RE: **Cloverleaf Filing No. 2 - Street Improvements**

RE: **Cloverleaf Filing 2 – Public Storm Sewer**

Attn.: Mr. Brad Walters, Inspection Supervisor  
RE: Cloverleaf Filing No. 2 – Pond Certifications

# V1\_Pond & Road Certification Letter.pdf Markup Summary

POND 1 PLAN

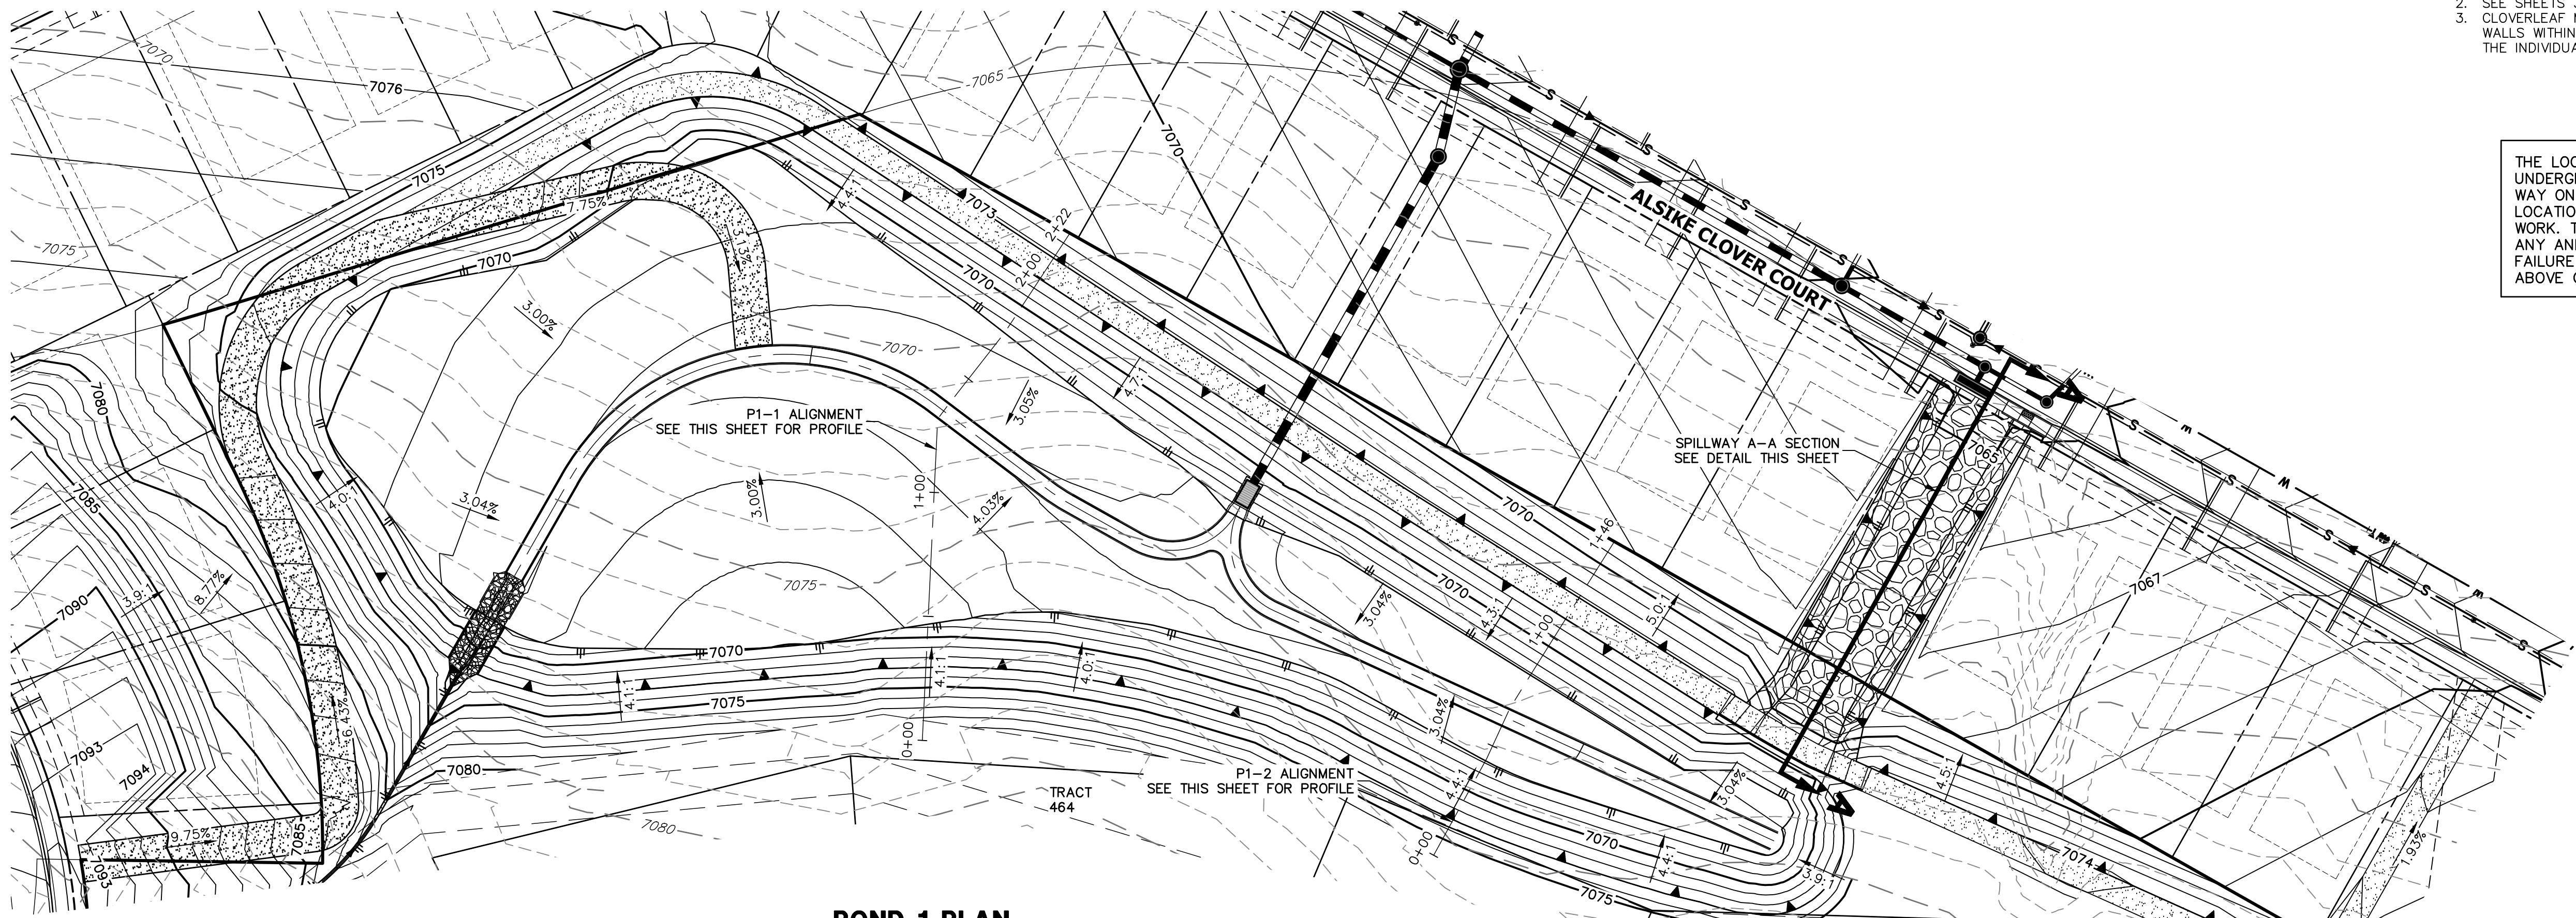
Was an as-built topo survey completed? It does not appear that the topo on as-built plans was updated to show as-built conditions.

Was an as-built topo survey completed? It does not appear that the topo on as-built plans was updated to show as-built conditions.
